Subject: DOCO comments for application 2025/91384 at 17 Market Street, Heckmondwike, WF16 0JY

Re: 2025/91384- Change of use of existing basement from storage (Class B8) to a single-person House in Multiple Occupation (Class Sui Generis), including internal alterations at 17 Market Street, Heckmondwike, WF16 0JY

Proposed Rear Elevation

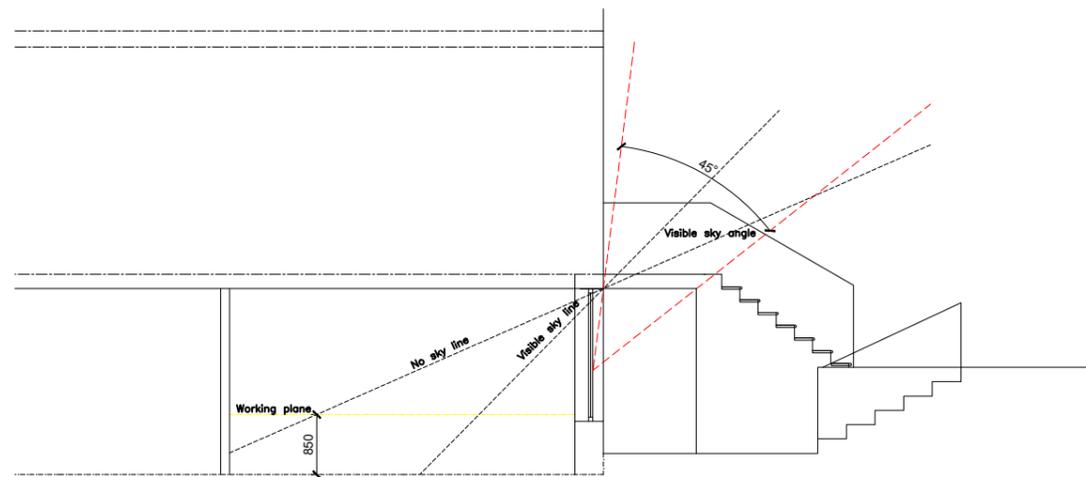
Arson- 2 of the offences related to refuse being set alight. It must be ensured that bins and litter belonging to all properties within the site (HMO bedrooms as well as retail) are stored securely and away from the new proposed entryway to the basement dwelling.

- for new doorsets:

Any glazing within PAS 24 or STS 201 certified doorsets, including glazed panels/ windows adjacent to doors installed within an integral door frame and windows adjacent to doorsets (within 400mm), must incorporate one pane of laminated glass certified to BS EN 356:2000 Class P1A, or above. This

- for the new window:

Laminated glass certified to BS EN 356:2000 Class P1A or above, is required in the following areas:

- any window located within 400mm of a doorset (to ensure the integrity of the locking system)
- easily accessible emergency egress windows with non-lockable hardware (a requirement of PAS 24).
